# Community Design Solutions

May 21, 2025

## RE: Comment Responses to DFT Comments Issued on 4/16/2025 for PR-2020-004098

The following are comment responses in response to the DFT comments issued for the post-EPC site plan signoff by DFT staff for PR-2020-004098. The comments were issued on the DFT hearing on April 16, 2025. The comments have been copied below, and CDS's comment responses are provided in [blue](#).

SEWER CONSTRUCTION NOTES	
I.D.#	DESCRIPTION
3	8" SEWER PIPE PER STANDARD SPECIFICATION SECTION 901
12	4" DIA. TYPE E MANHOLE PER ABCWUA STANDARD DETAIL 2102.
21	4" SEWER SERVICE PER ABCWUA STANDARD DETAIL 2125

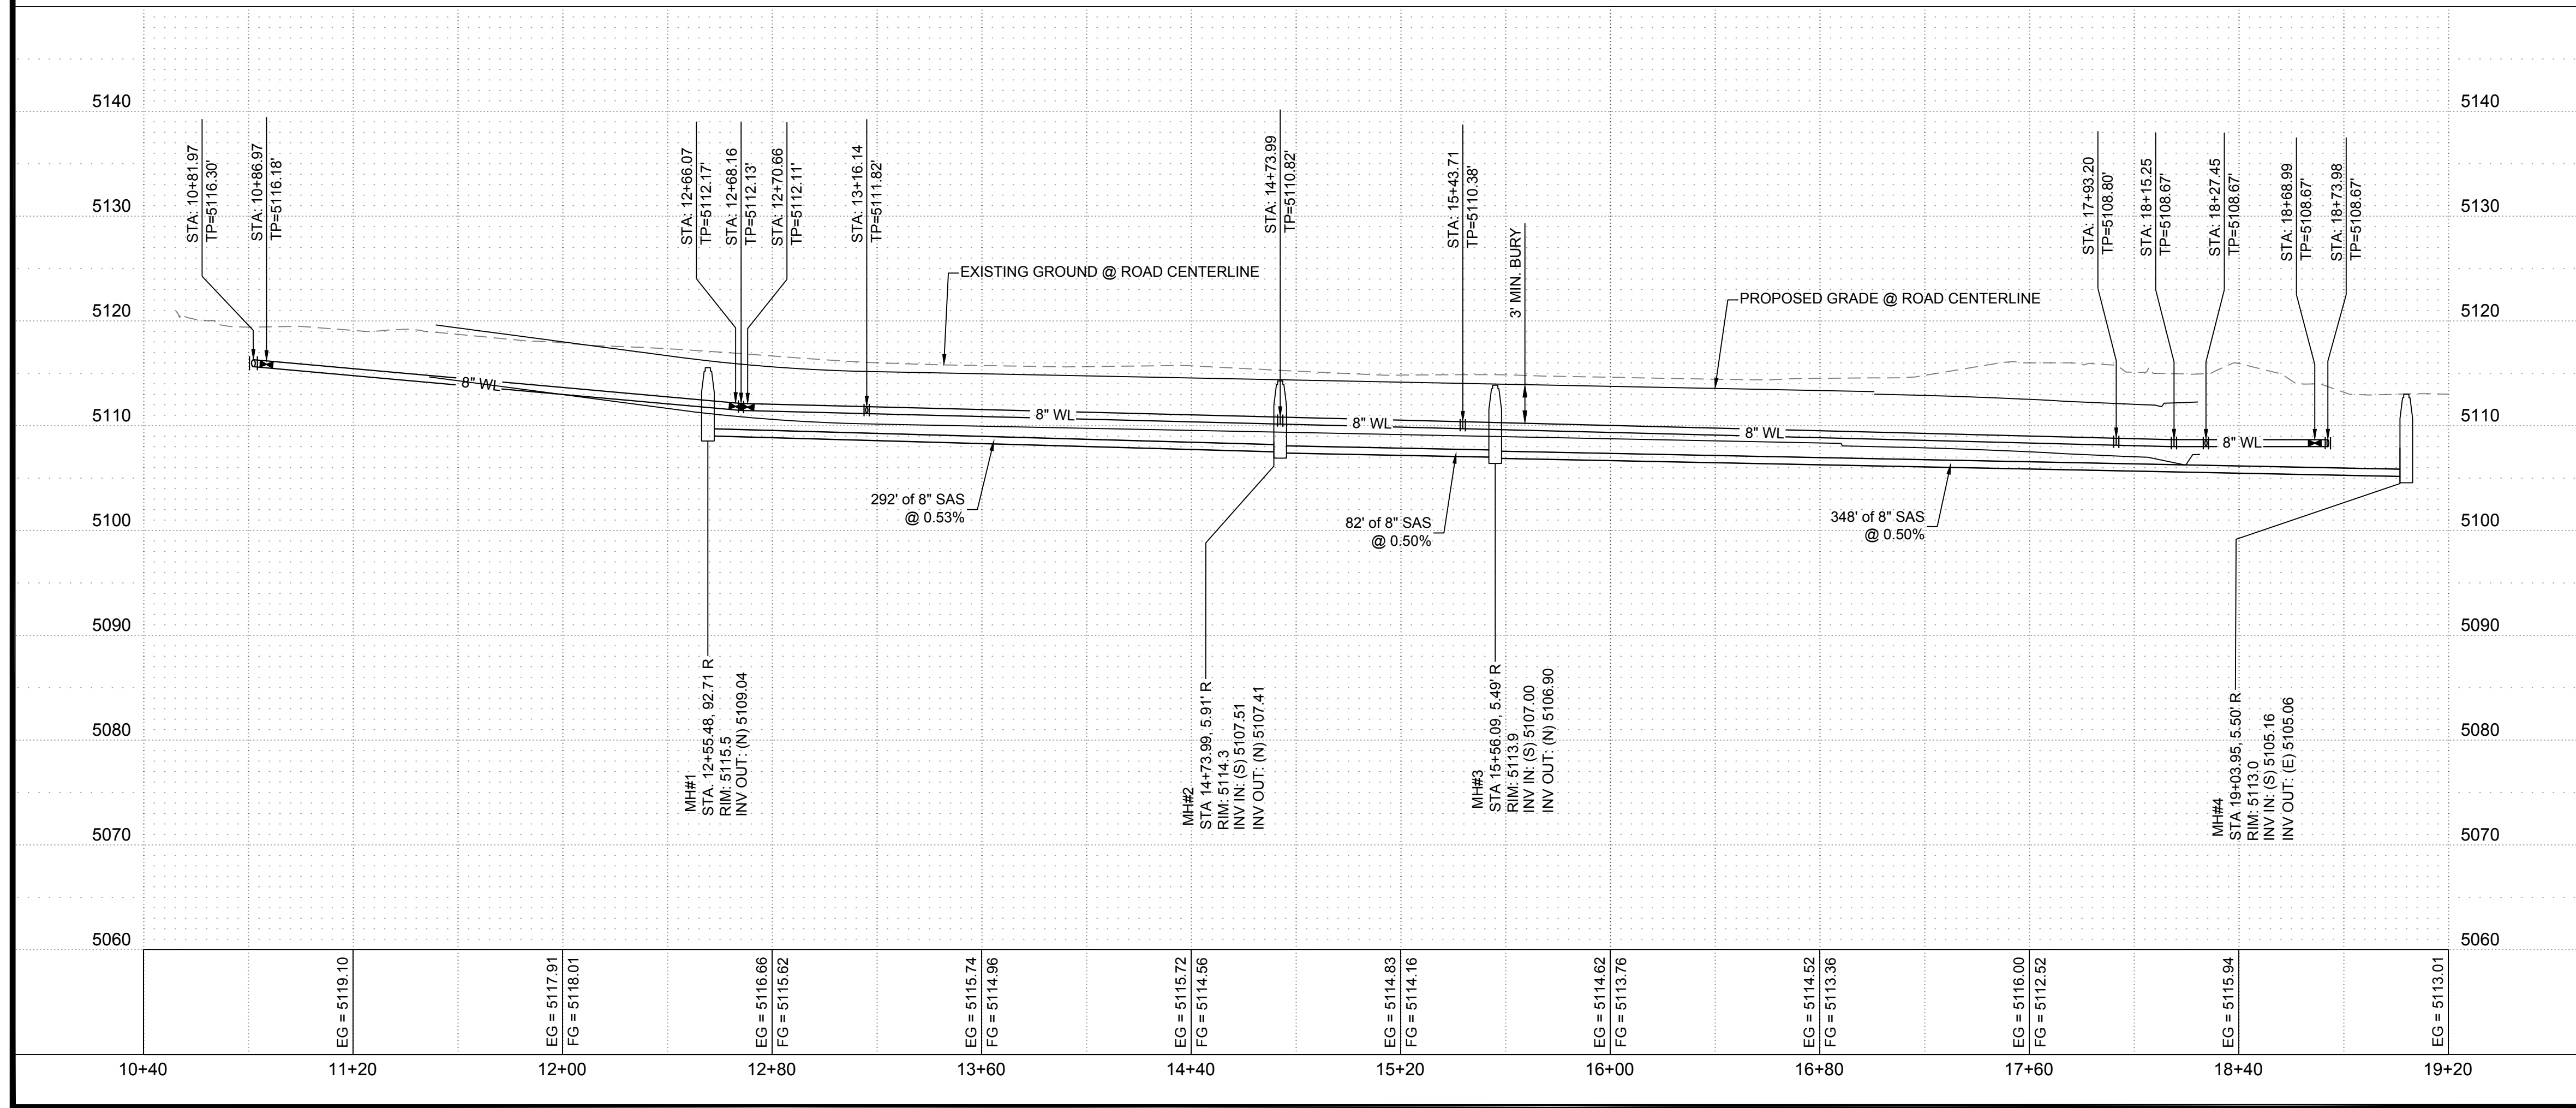
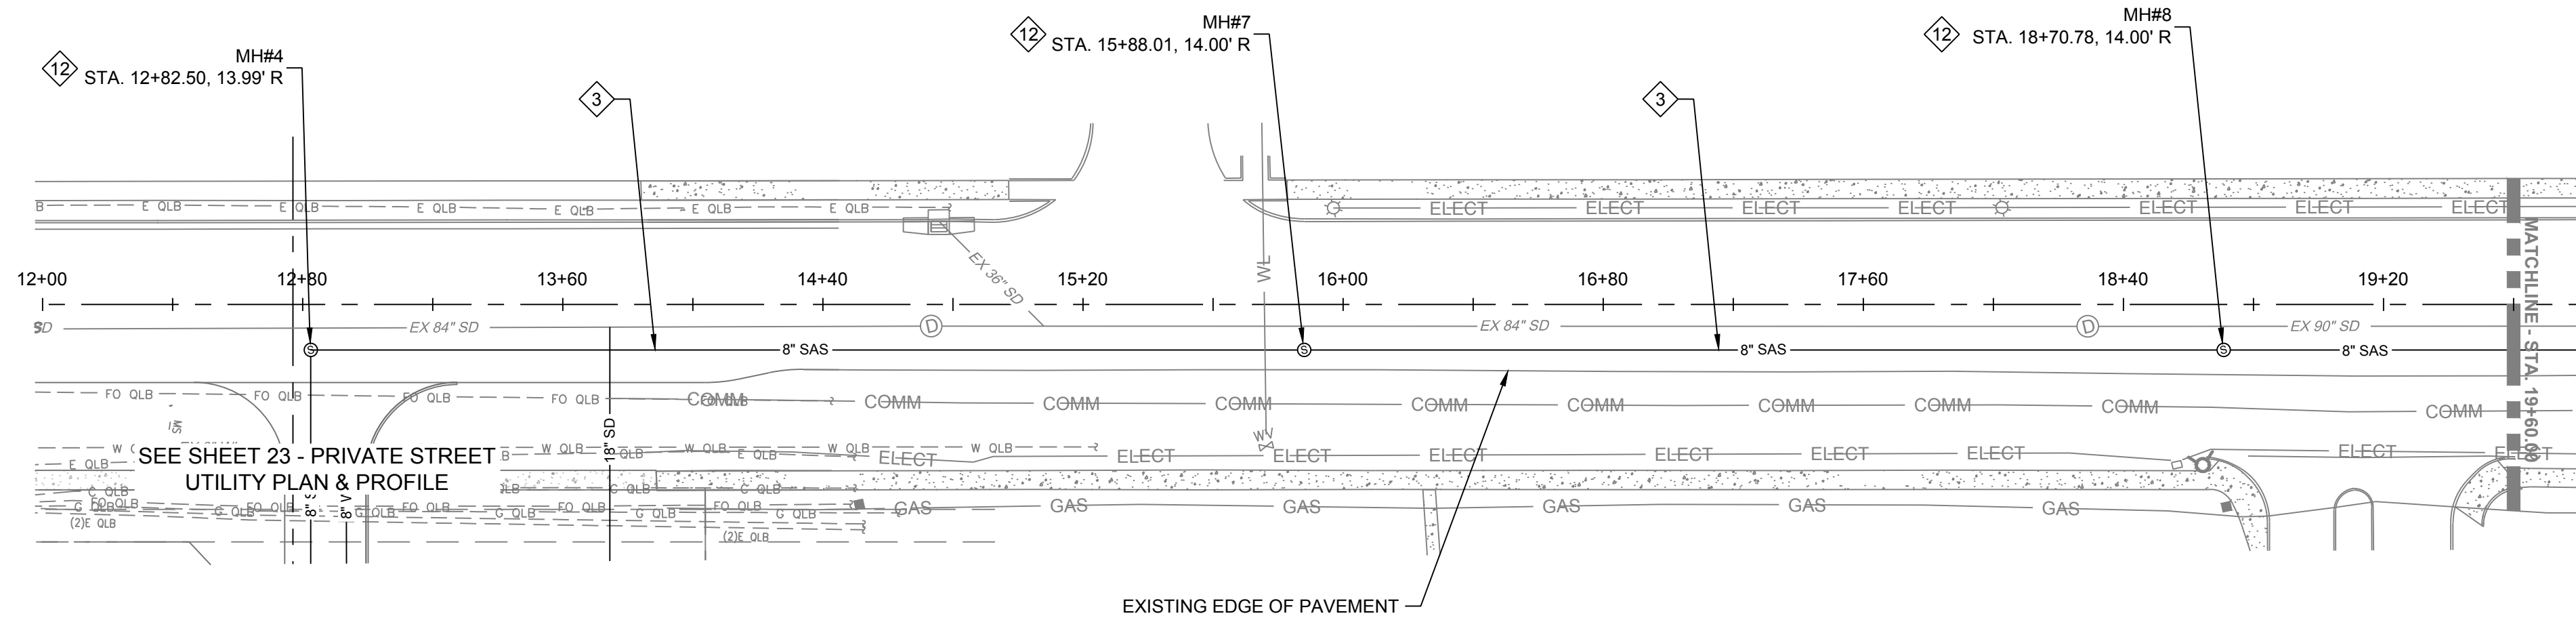
- i. [Not used](#).
    - ii. Dimension the public water and public sewer easements on the utility plan. [The updated utility plan contains the utility plans from the construction plans currently in review at DRC. Public water and public sewer easements are shown, labeled, and dimensioned.](#)

- vi. Show existing public water and public sanitary sewer mains and associated easements on the utility plan. The existing public 8-inch collector sewer line in Bridge Blvd is missing on the plan. Also, show the alignment of the developer-funded sanitary sewer line extension from the property to the existing public 8-inch sanitary collector line in 82nd St. [Done.](#)

- c. The proposed sanitary sewer line shows what to appear to be manholes at the flowline of the street (c&g). Manholes must not be placed within the flowline. [Plan has been revised to move manhole out of the street flowline.](#) Additionally the south end of the subdivision shows a proposed manhole potentially that appears to be abutting the perimeter of the site. Please ensure there is additional easement south of the manhole and that the Water Authority has access to the manhole and no cars can be placed on top of the manhole. A large Vector Truck must be able to access all proposed manholes. [Plan has been revised to move the manhole further into the alley and away from the perimeter of the site.](#)

**Interior
Planting Plan**

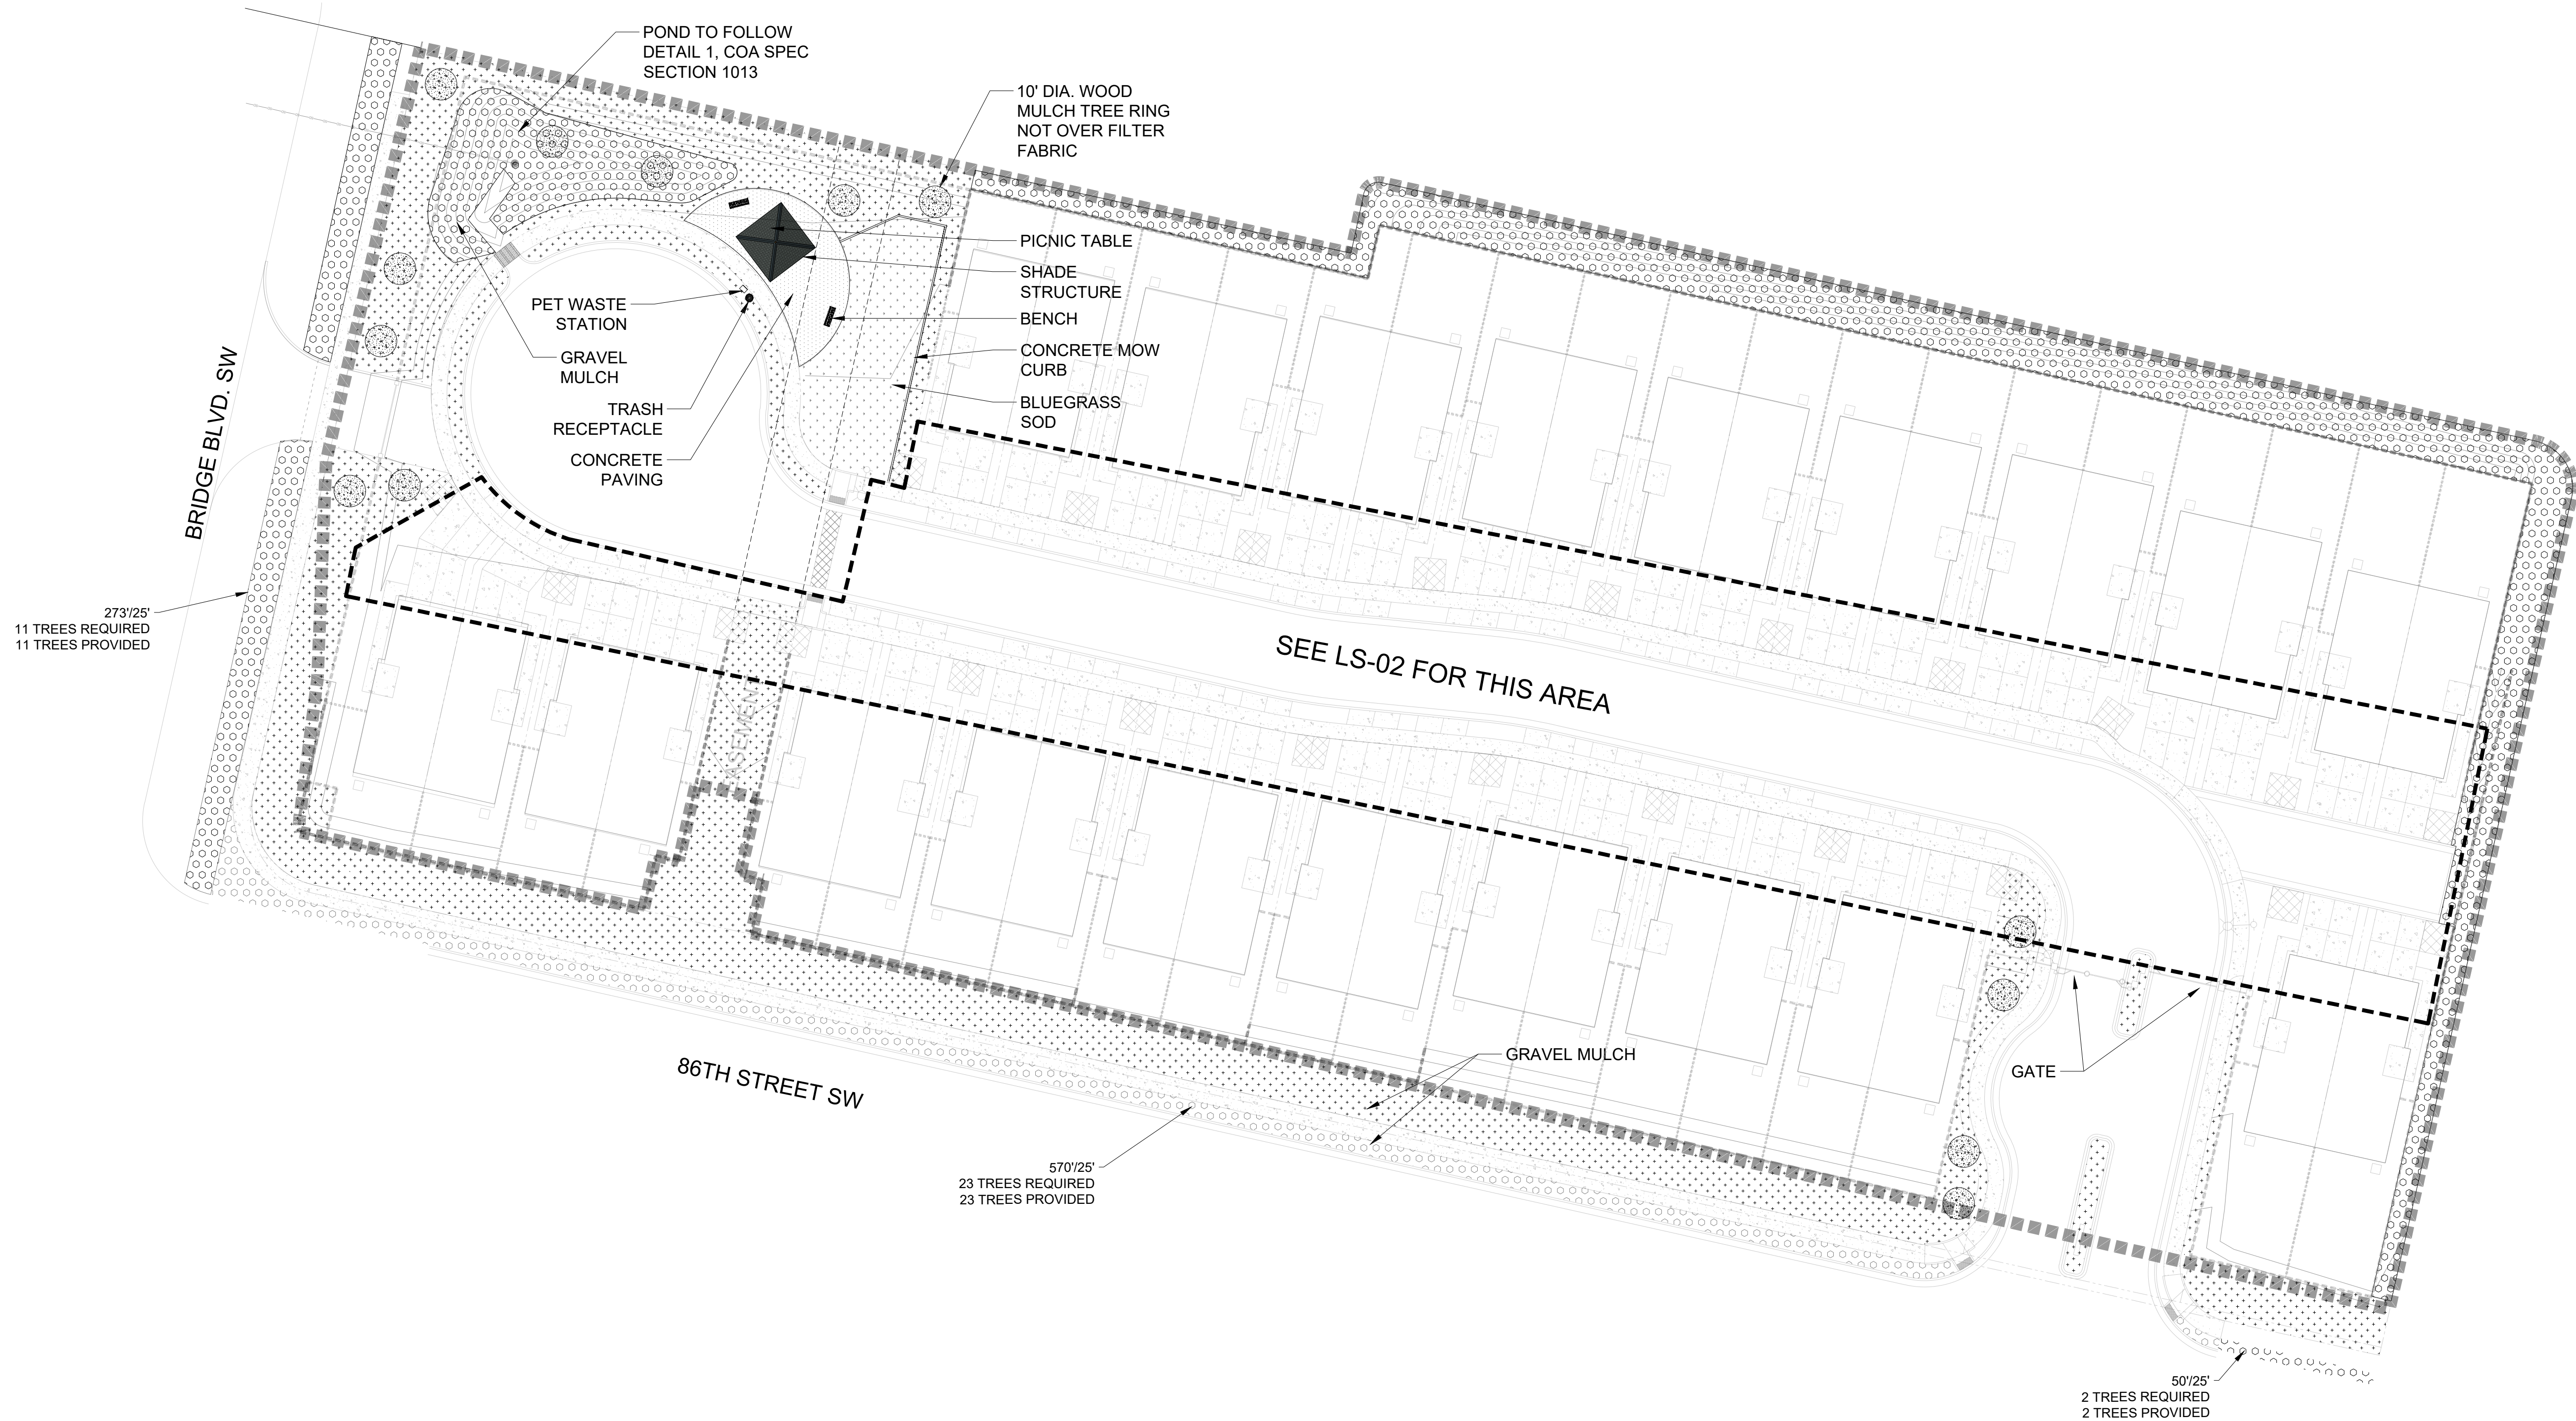
- iv. There shall be no trees, parallel fences/sidewalks/curbs, or structures within the public water and public sewer easement. Please revise accordingly. [Landscape plan has been revised to remove trees from the public water and public sewer easement. The proposed easements are generally within the roadway along lip of gutter except at the site entrance where the edge of the water easement aligns with the face of the median curb.](#)

Per City Forestry: The Urbanite Ash proposed is conditionally recommended in the Official Albuquerque Plant Palette; “existing population of eastern/American ash have been dying due to heat and drought”. Please replace this species with other types of street trees. [Landscape plan has been revised accordingly.](#)
